Re : Application Number 19/01271/F

As requested I am writing to formally advise the planning committee of my objection to this application. The reasons I will outline below –

Drawing:
PLOT 2 – PROPOSED PLANS

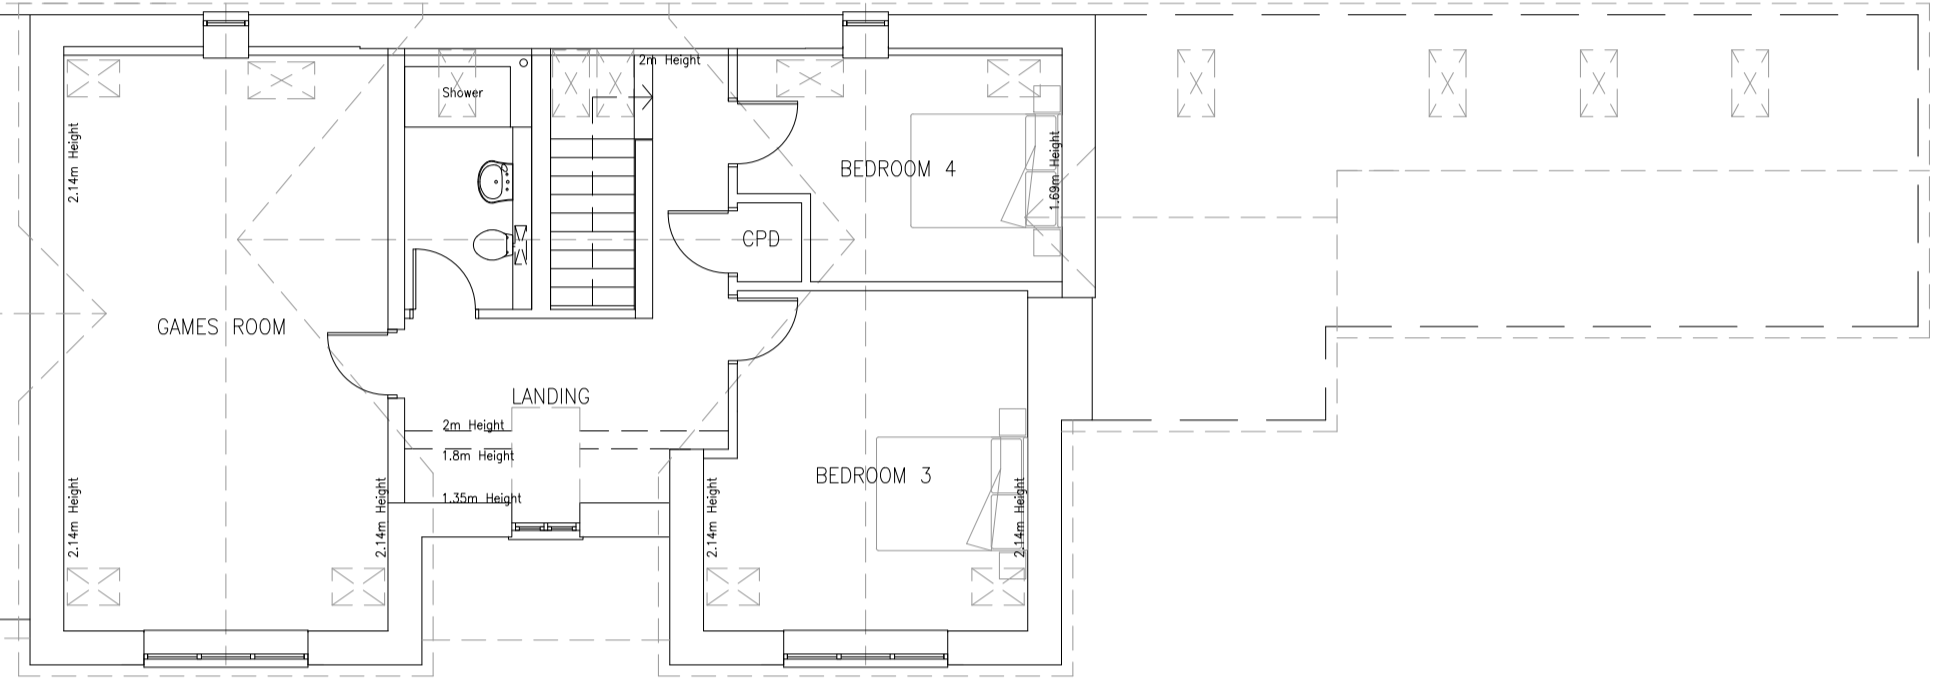
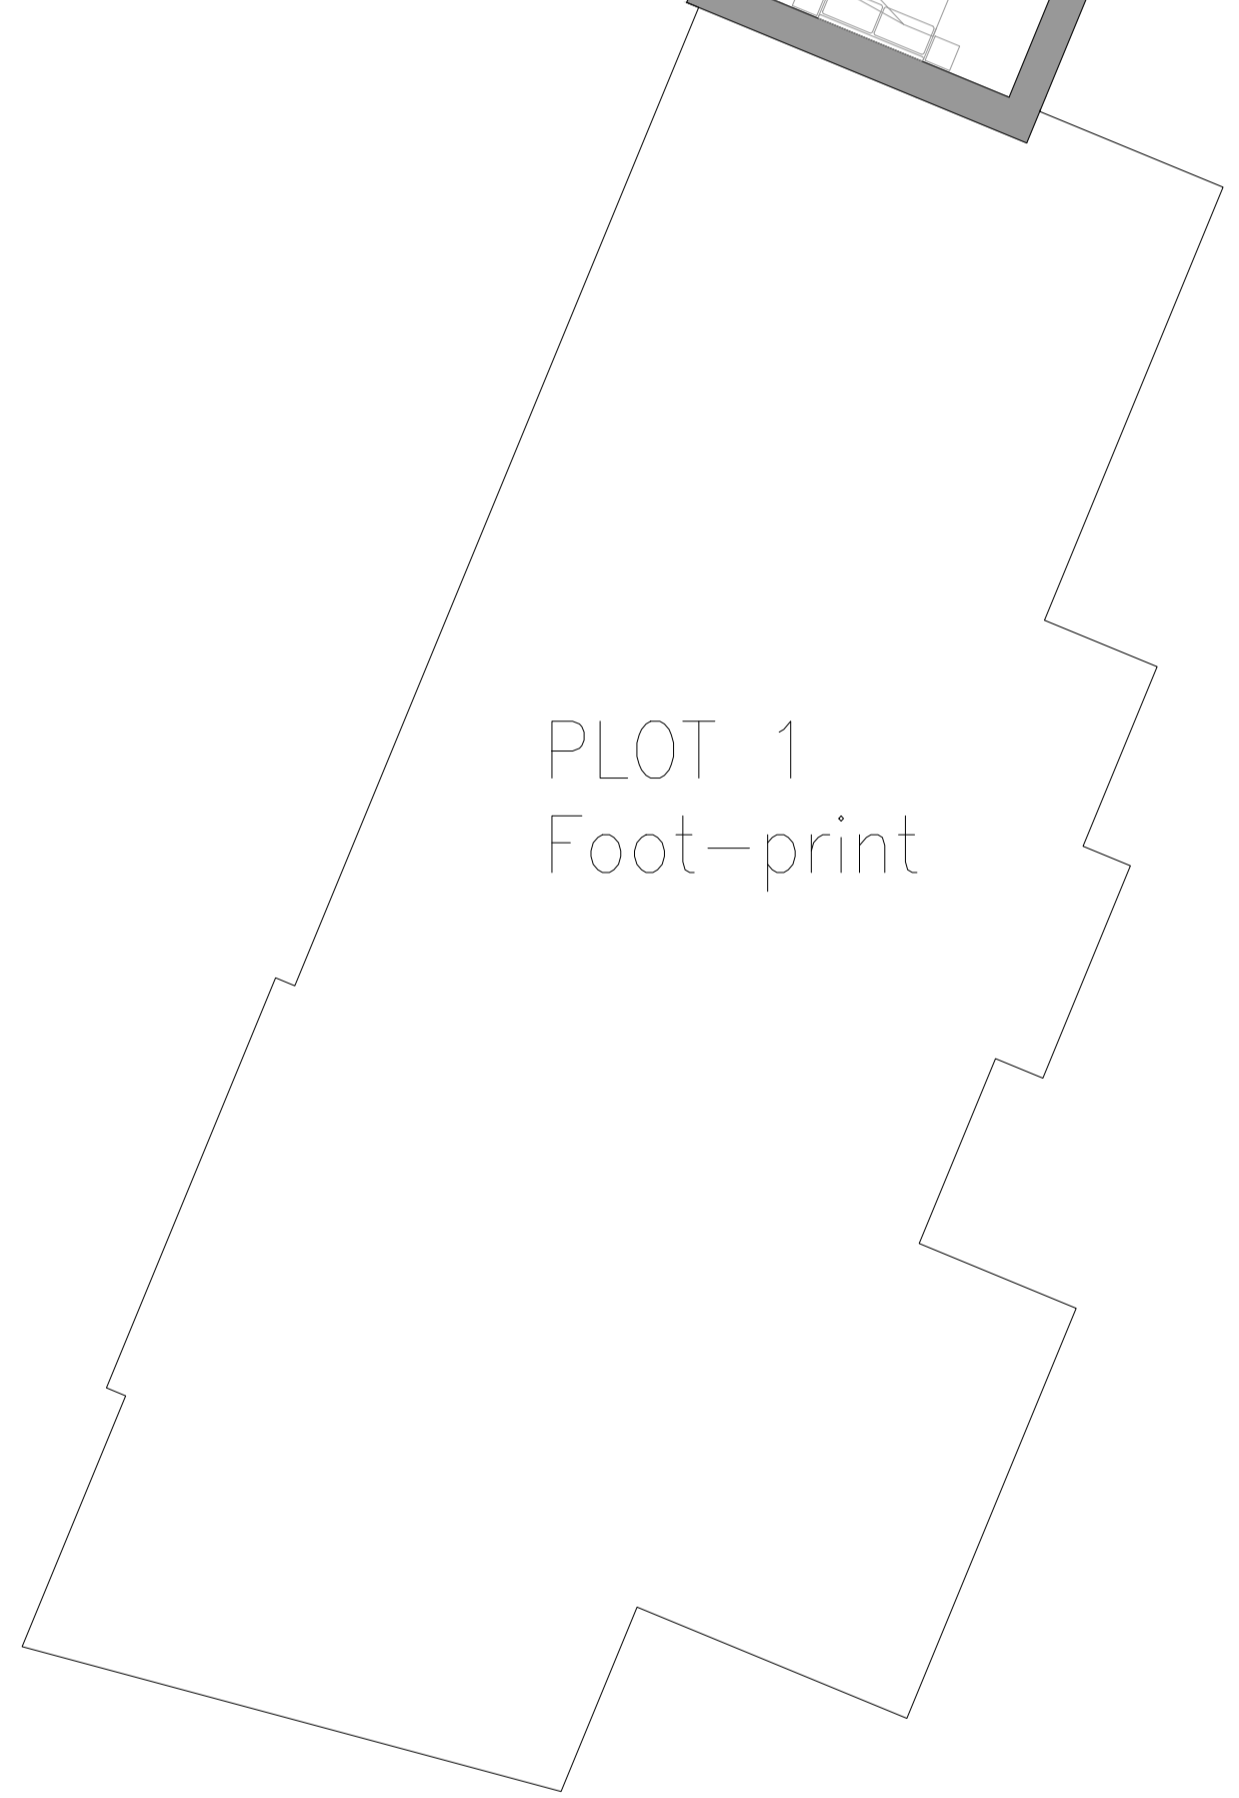
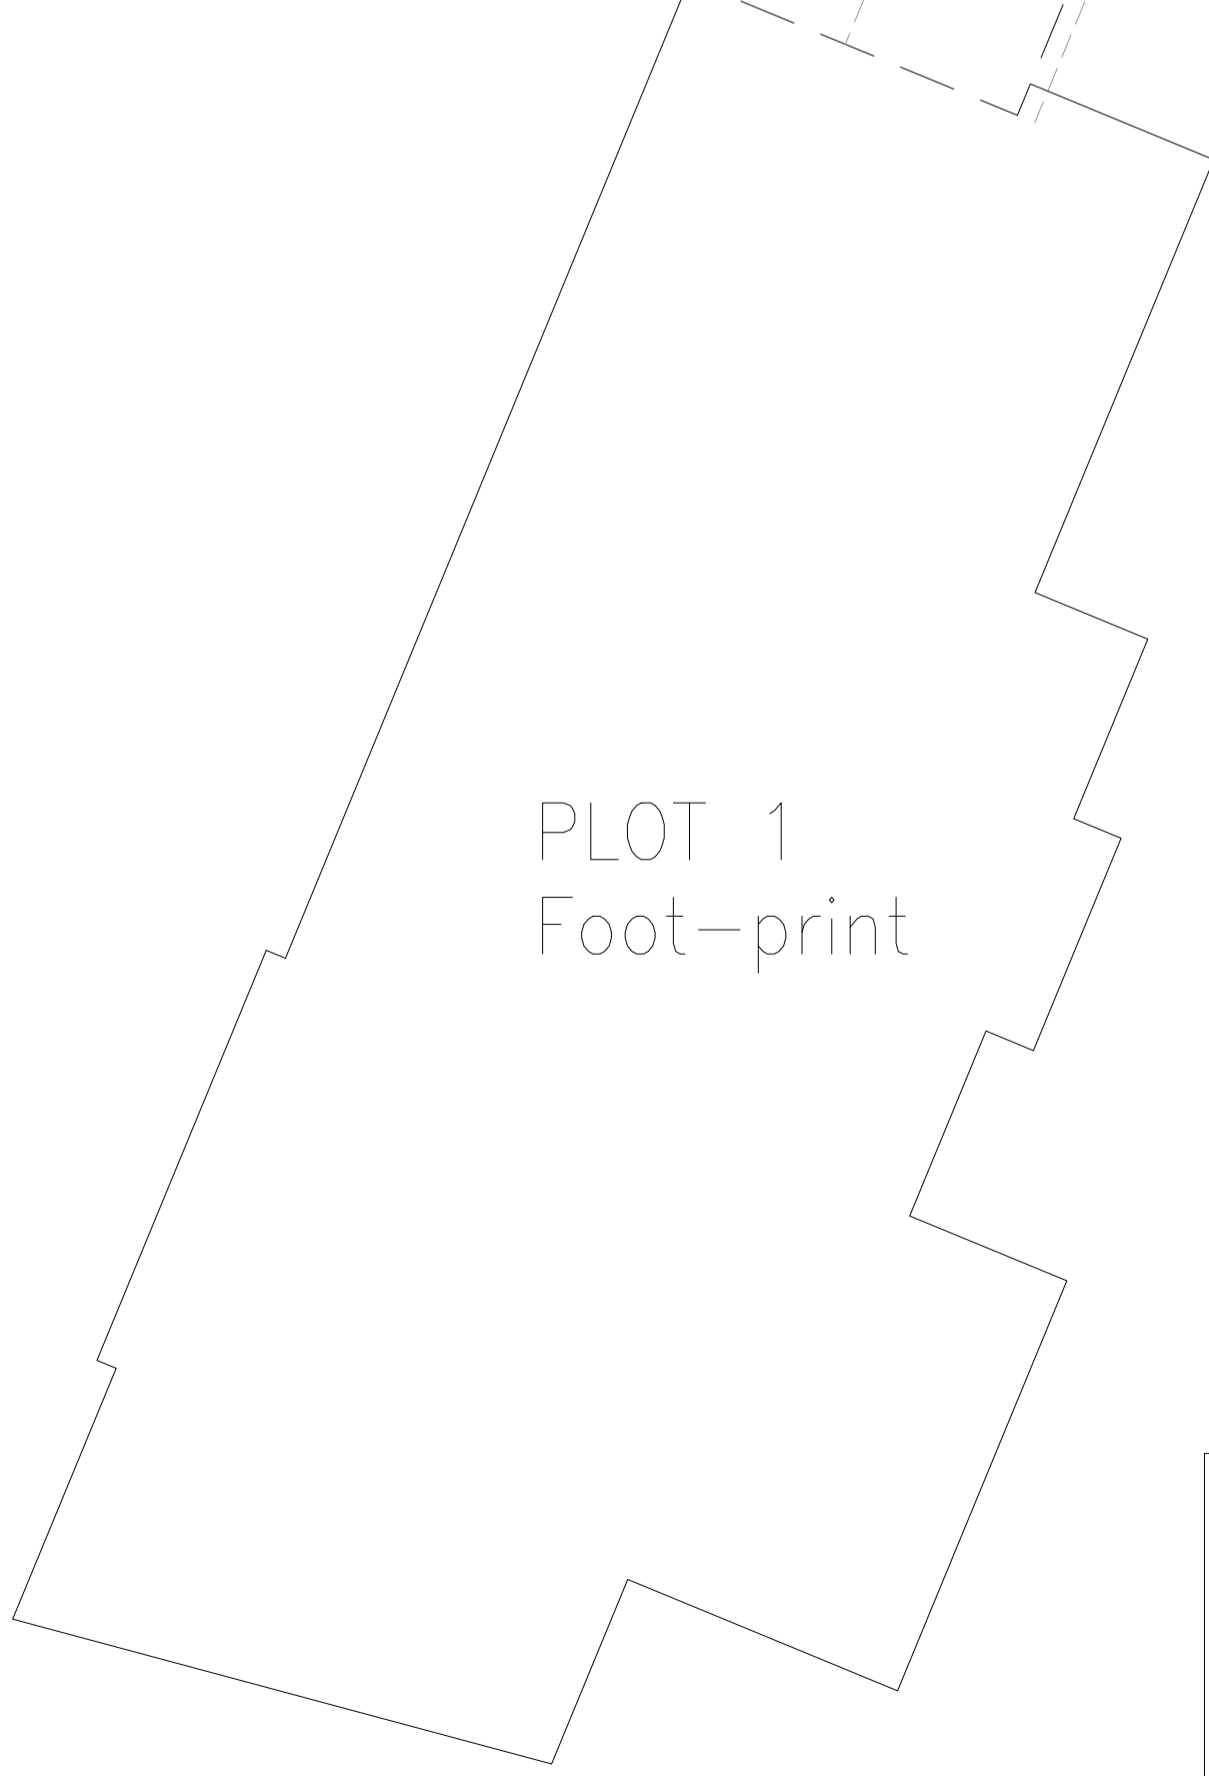
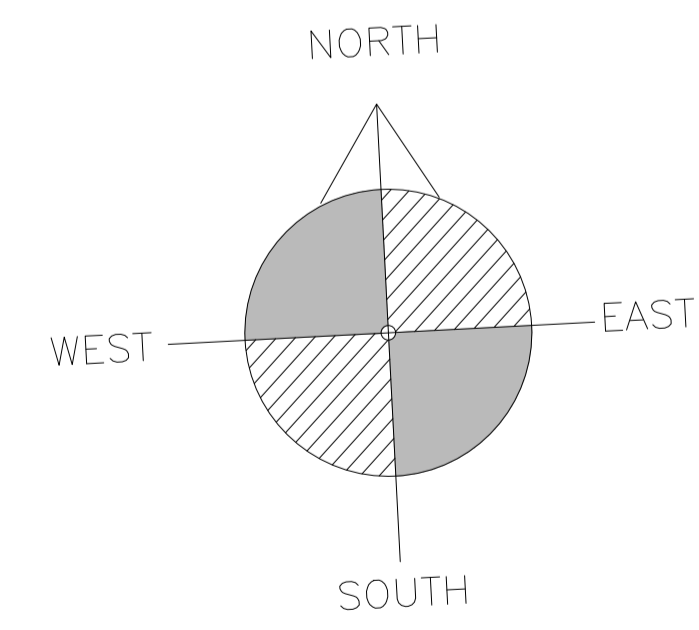
Layout and density of building – The layout of the buildings proposed do not sit on it's existing footprint. It has been considerably extended in these plans, and we believe in the past without having gained planning permission. In plot two the layout proposed could easily accommodate 6 or 7 bedrooms in actuality. Vaulted ceilings are now proposed for a building that was originally specified by Cherwell District Council was to remain as single storey. Significant new outbuildings are being proposed (garages

and workshops) within both close proximity to Brashfield House. I think there are guidelines that protect listed buildings against such development within a conservation area that should be adopted here.
